Our Ref LH9500 L002 Stanton Dahl Planning clarification:KL
 Contact Kevin Leedow

**WAHROONGA SEVENTH DAY ADVENTIST COLLEGE
 FOX VALLEY ROAD WAHROONGA**

With regard to the submissions from various Government Departments, conveyed via the Department of Planning and Environment, for the proposed Wahroonga Adventist School, Wahroonga (SSD 5535), we note below responses for various queries related to Civil Engineering (including stormwater), Electrical Engineering (including lighting) and Acoustic Engineering.

playing fields plan
job number 1318.10
dwg. no. / issue & amendment DA17 / 2

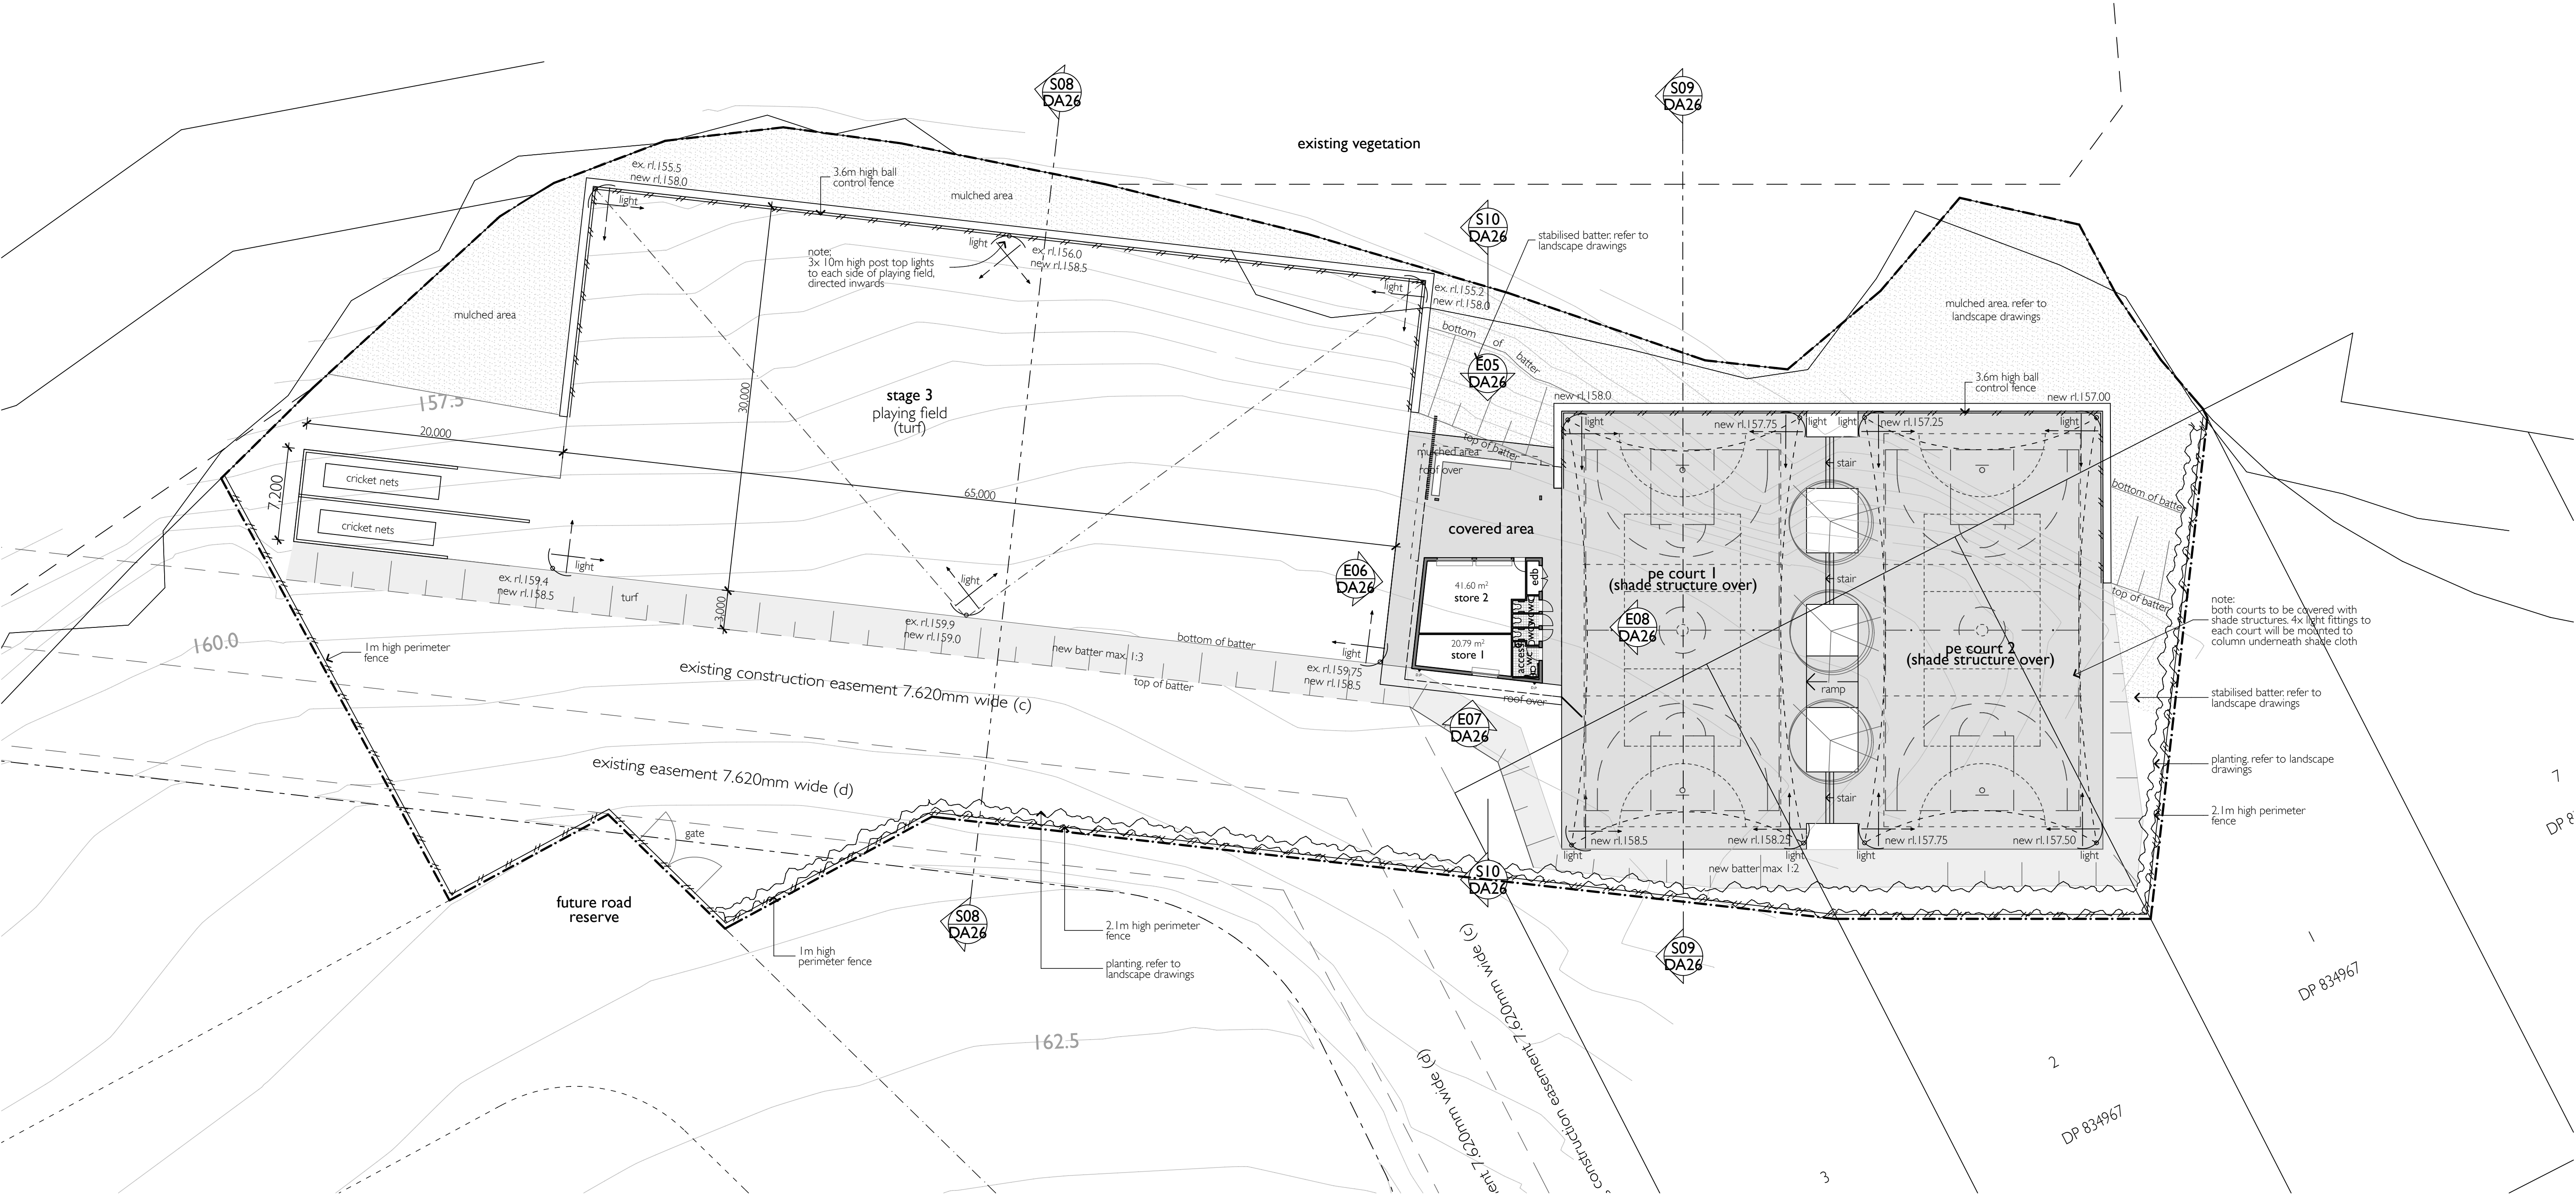
Item	Comments
WSUD for playing fields	The treatment of nutrient loaded run off from the playing fields will be treated with a gross pollutant trap and biofilter such as Humes 'Humeguard' and "hydrofilter". These devices will be sized and the MUSIC model amended in the detailed design phase.
Impact of the playing fields and PE courts on the overland flow and water course	A catch drain has been provided on the uphill side of the playing fields to divert upstream overland flow. Refer to drawing LH9500-2103 Stormwater Drainage Plan Playing Field and PE Court.
Piped drainage design requirements in accordance with DCP 47	DCP 47 requires the piped drainage design to be sized for the 50 year storm event. The detailed design will reflect this storm event. The change from the 20 year storm to the 50 year storm will not change the concept design for the stormwater.
Location of dispersion trenches	The dispersion trenches for the playing fields and PE courts are located at the base of the retaining walls for the fields and courts and will impact the design of the retaining walls. The detailed design of the retaining walls will account for the location of the dispersion trenches and will effectively be designed for a retained height from the invert of the dispersion trenches to the upper level of the fields.
